Application Reference: 2026/0146

Site Address: 1 Watermans Cottages, Whams Road, Hazlehead, Sheffield, S36 4HJ

Introduction: This application seeks full planning permission for a Two storey rear extension to dwelling

Drawing Number: 2195/TP/005

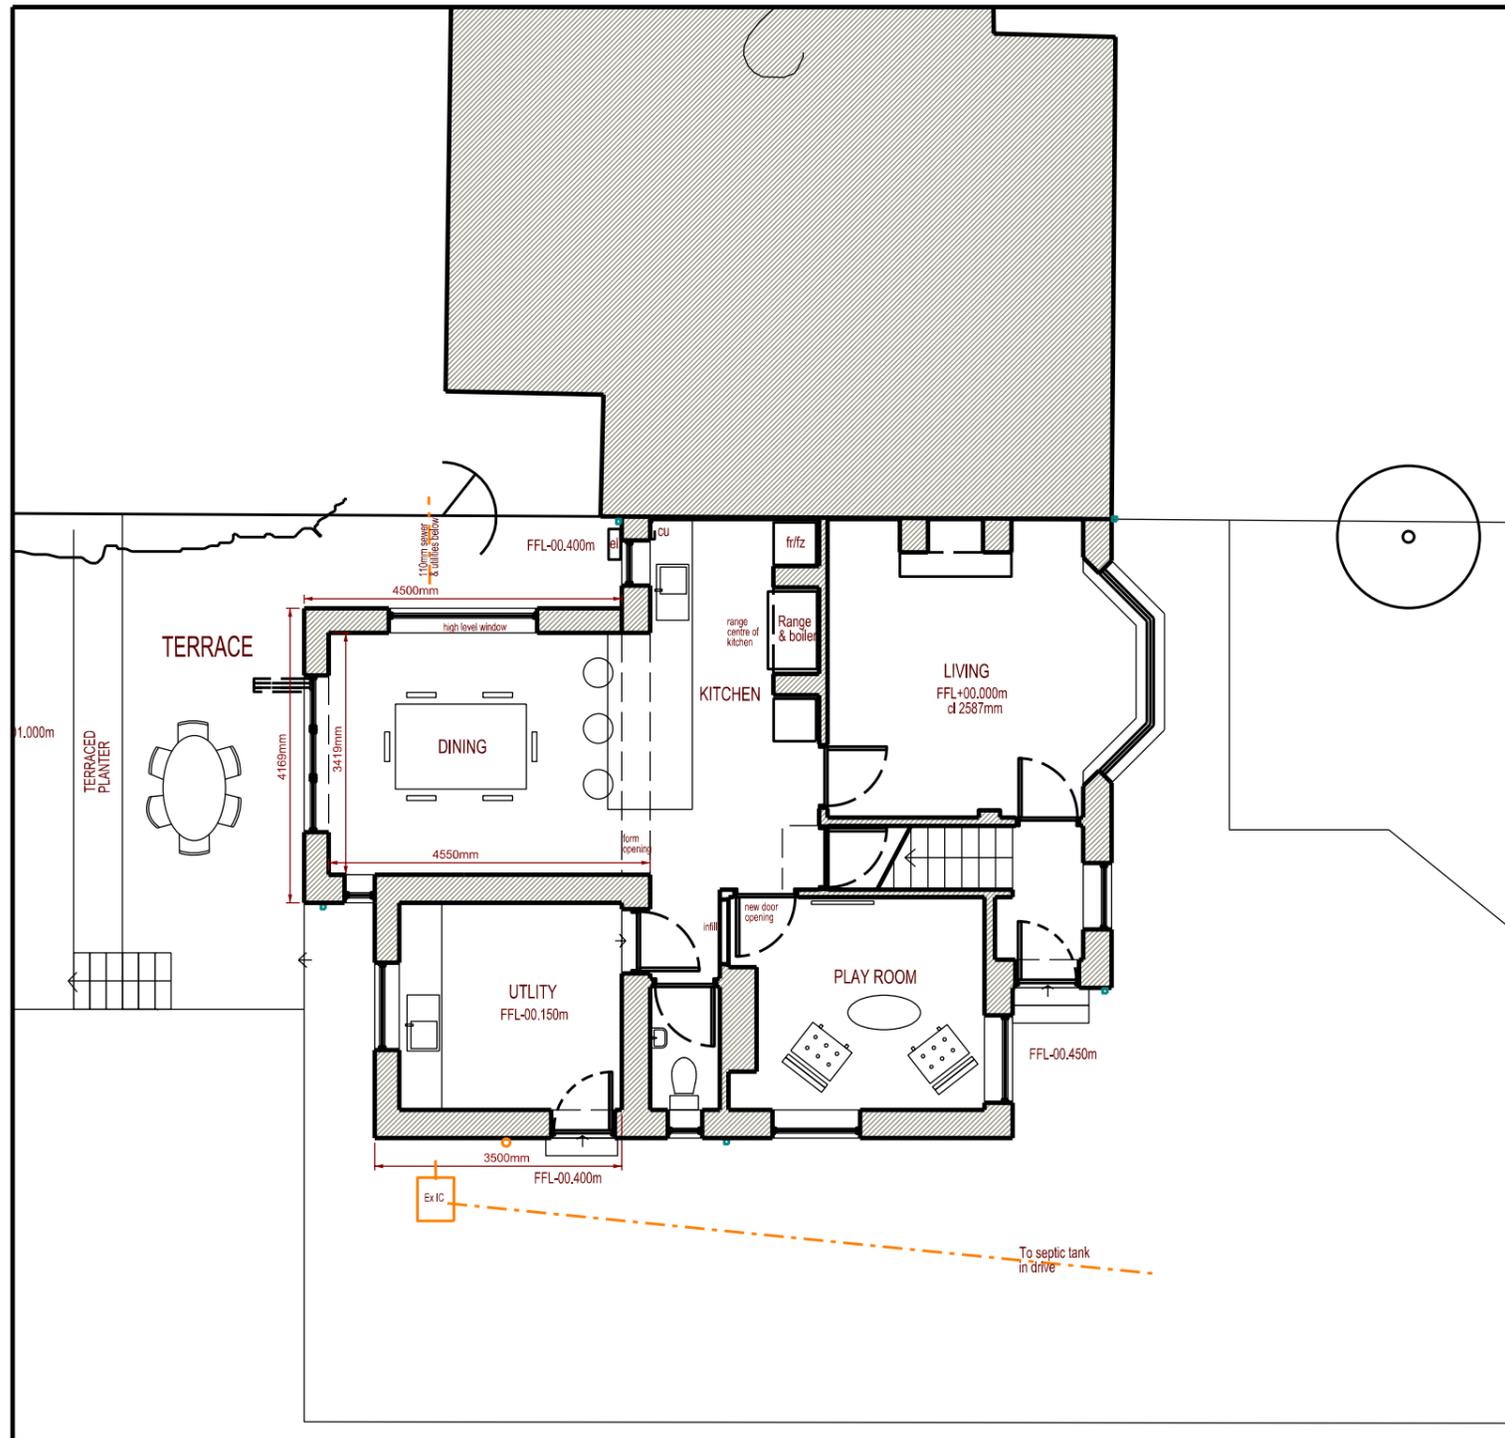
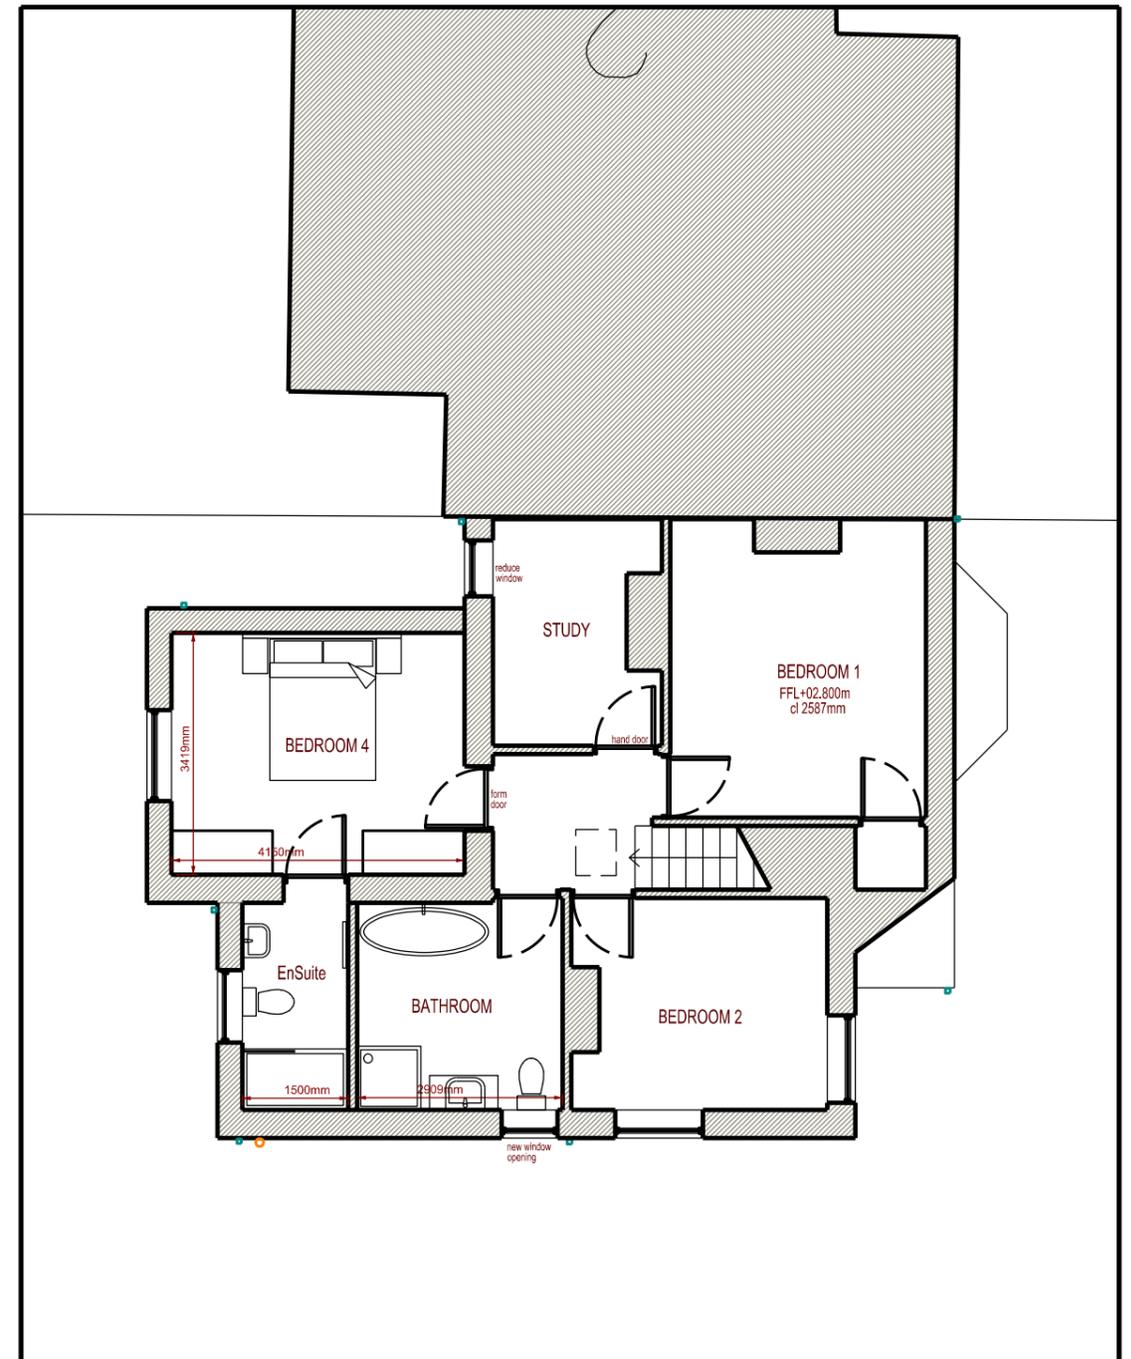
The proposal is for a relatively modest sized two storey rear extension, approximately adding 37sqm of external floorspace to the original dwelling's 141 sqm external floorspace. The extension would be located on the rear elevation of the dwelling but as the rear elevation of the existing dwelling, and its neighbouring counterpart are stepped, both horizontally and vertically, the proposed extension is not a typical cuboid shaped extension and therefore lacks a consistent sized rear projection or equal sized elevations.

At ground floor level the majority of the proposed extension would only be 2.45m beyond the main aspect of the rear elevation. For a small aspect of the ground floor extension, and the largest section of the first-floor extension would feature a rear projection of 4.5m, creating the first two storey gable. A second section of the first-floor extension would feature a rear projection of 2.5m, creating the second two storey gable aspect of the extension. Despite, these peculiarities, as the additional floor space remains proportionate to the dwelling, in terms of scale, it would only have a modest impact on the scale of the original dwelling, significantly supported by its location on the least visible aspect of the dwelling, its rear elevation.

Due to the isolated location of the dwelling with Whams Lodge and Don View Bungalow too far away to be impacted by the proposal, any potential impact would be on the attached neighbouring dwelling of No 2 Watermans Cottages. There is a slight encroachment into the 45 degree exclusion zone, however, given the stepped design of the dwellings, with an approximate inset of 3m between the existing rear elevation conservatories of both dwellings; the conservatories already breach a 45-degree angle for each of the dwellings very small kitchen windows. For the ground floor at least, any increased impact would be minimal. For the first-floor window, because of the larger size of the window, the breach is not as significant as would be on the ground floor, with only a small corner section of the extension potentially breaching the 45-degree from the centre of the neighbouring first floor window.

In addition to the breach of the 45-degree rule, the proposal may be considered a little overbearing but given the projection of the rear extension is a maximum of 4.5m from the inset and only 2.45m from the original ground floor conservatory, the proposal would not cause a significant impact on the amenity of No 2.

Drawing Number: 2195/TP/003

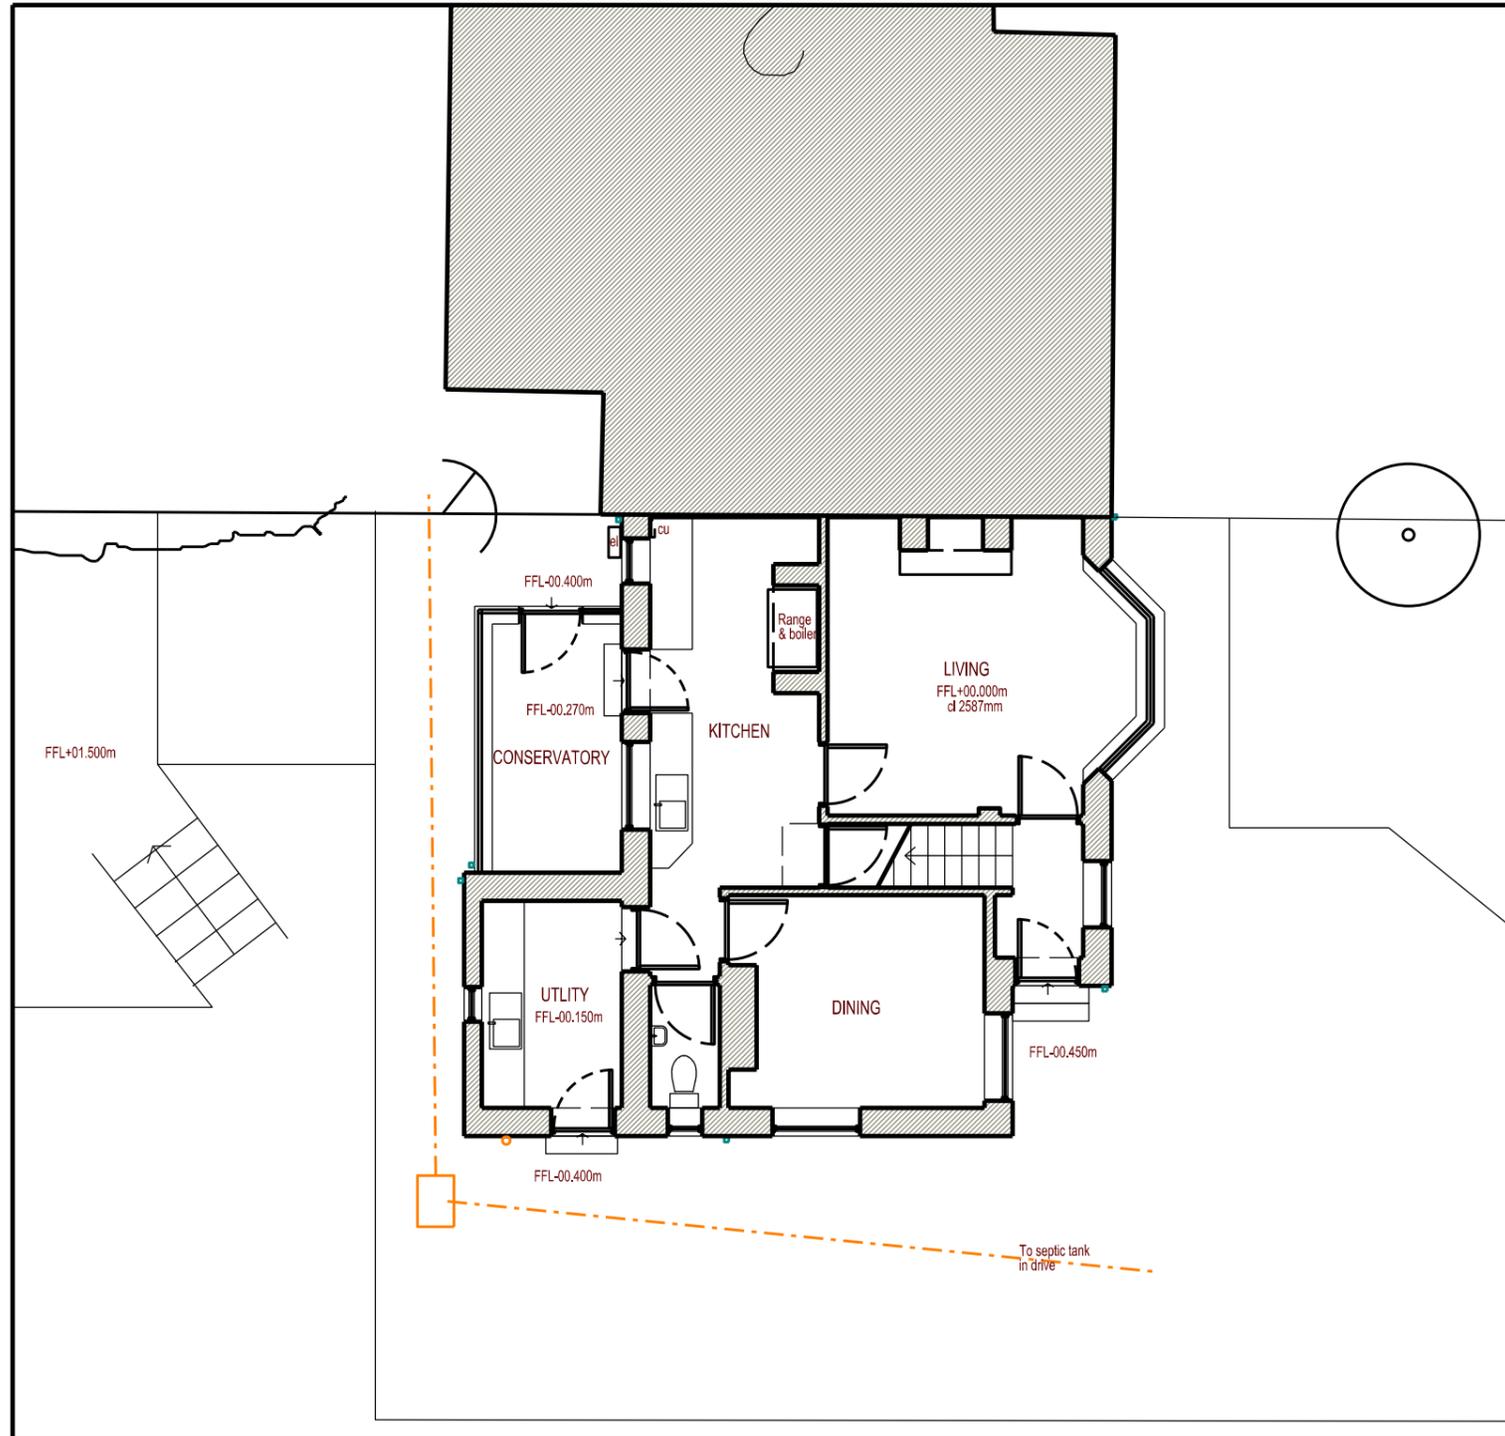
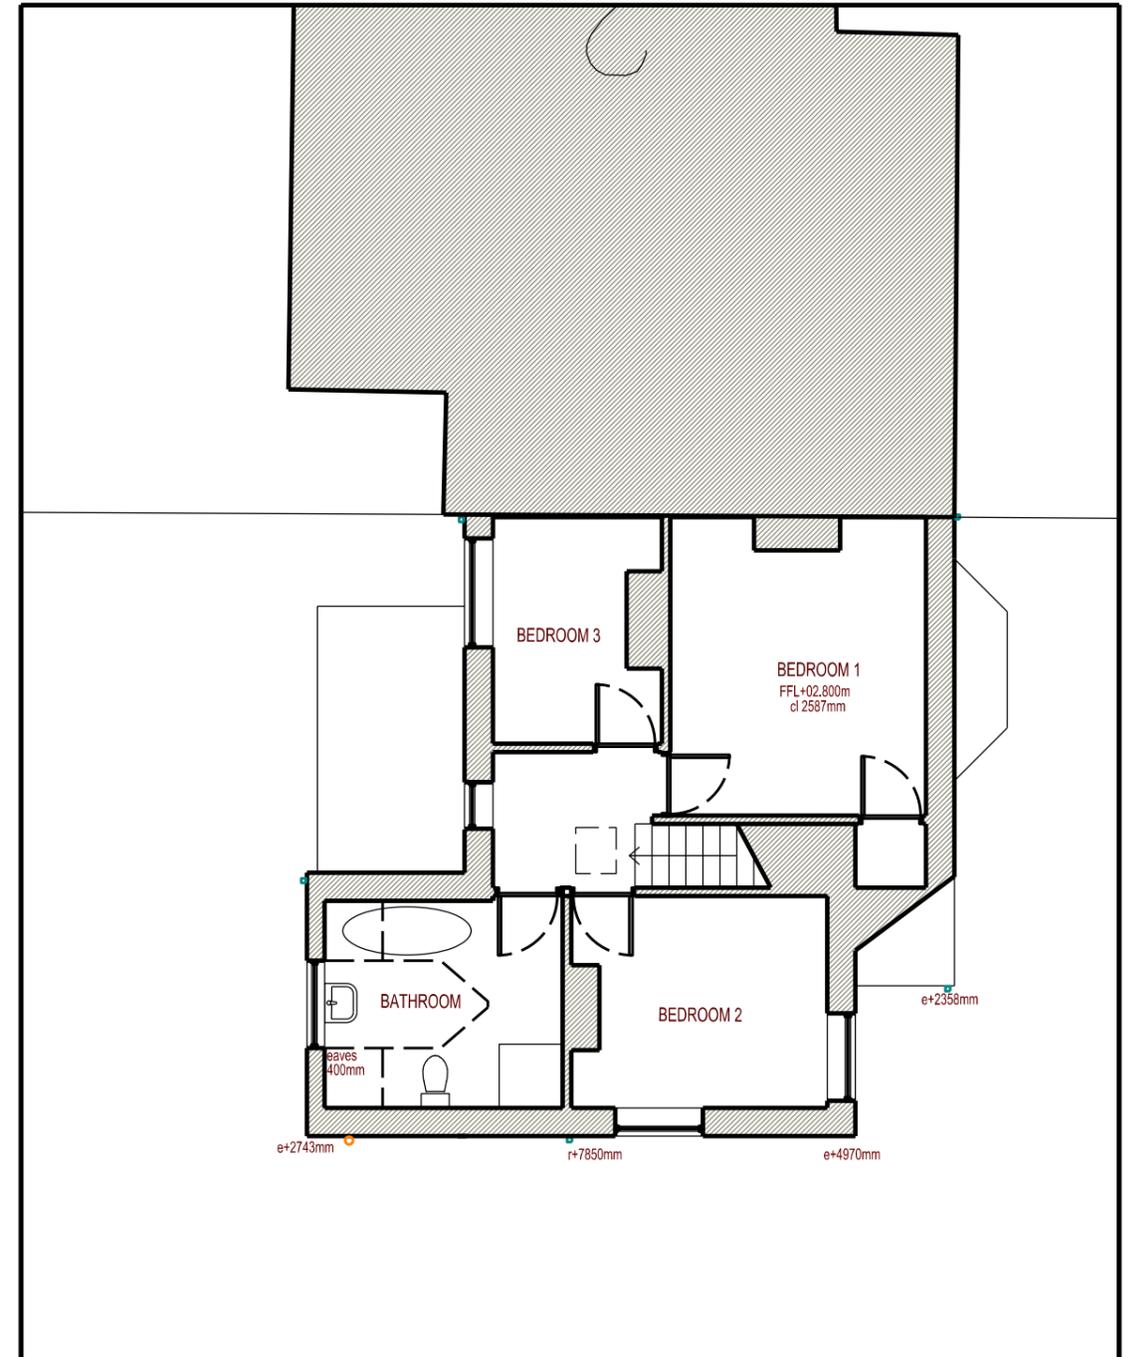
The supplied plan 2195/TP/003 provided a ground floor footprint which largely aligned with the most accurate 1960's OS map we have on file, along with a first-floor plan which is not indicated on the 1960's OS map, and plan 2195/TP/003 which provides the measurement for the existing outbuilding.

- Original dwellinghouse – 141 sqm (76 sqm ground floor & 65 sqm first floor)
- Existing extensions – n/a
- Existing outbuildings – 16 sqm
- Proposed additions – 37 sqm
- Total existing and proposed additions – 53 sqm
- Total resulting cumulative floor space – 194 sqm.
